Application by Five Estuaries Offshore Wind Farm Limited for the Five Estuaries Wind Farm

The Examining Authority's DRAFT written questions and requests for information (dWQ1)

Issued on 30 August 2024

**Figure 1 Design Review Process**

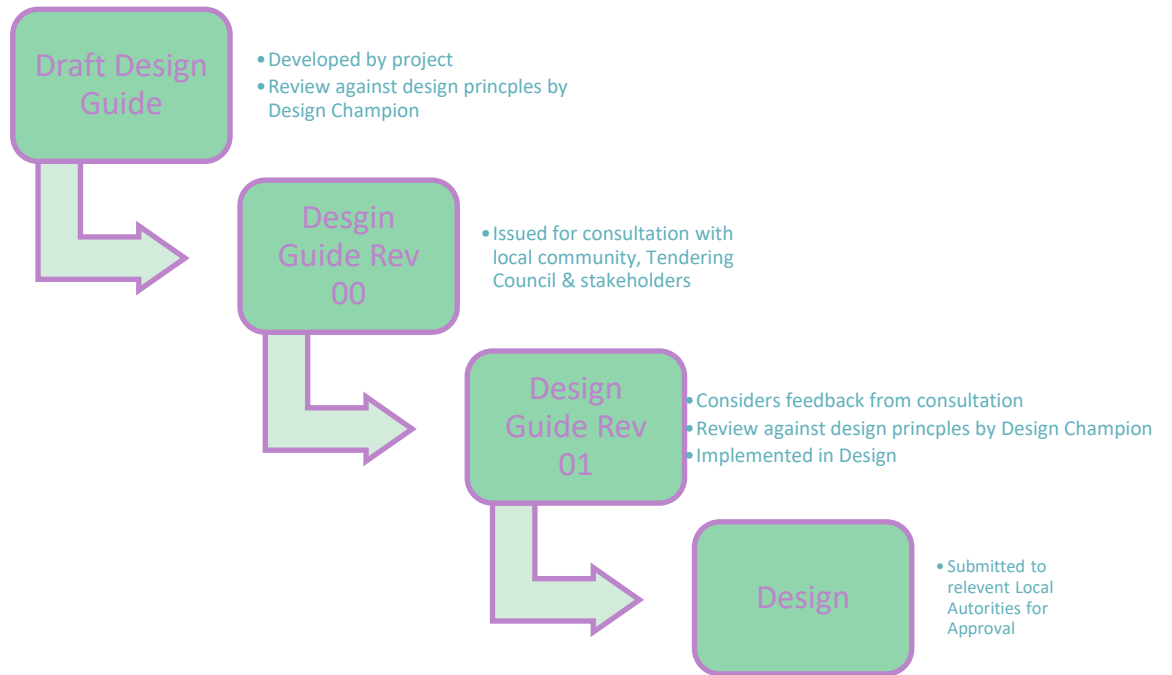
Question to:	Question
GC.1.15	Applicant	<p>Designing the proposed onshore substation</p> <p>Section 2.3 of the onshore substation design principles document [APP-234] refers to a design review process being used to finalise the design for the proposed onshore substation. Who would be the “<i>Project Design Champion</i>” and who would be the members of the “<i>Design Review Panel</i>”?</p>
GC.1.16	Applicant	<p>Onshore substation design principles</p> <p>In terms of selecting a location for the proposed onshore substation, paragraph 3.2.5 of the OnSS design principles document [APP-234] refers to, amongst other things, “<i>The Horlock Rules</i>”. What are the Horlock Rules? In answering this question a copy of the Horlock rules should be submitted.</p>
GC.1.17	Applicant	<p>Offshore Decommissioning</p> <p>Within the Application documentation it is submitted that the effects associated with the decommissioning of the offshore works would be similar to the offshore construction works for the Proposed Development, is that proposition correct? For example, would the process of dismantling the wind turbine generators, including removing their piled foundations, have effects for marine ecology similar to those associated with the undertaking of piling and the pouring of concrete?</p>
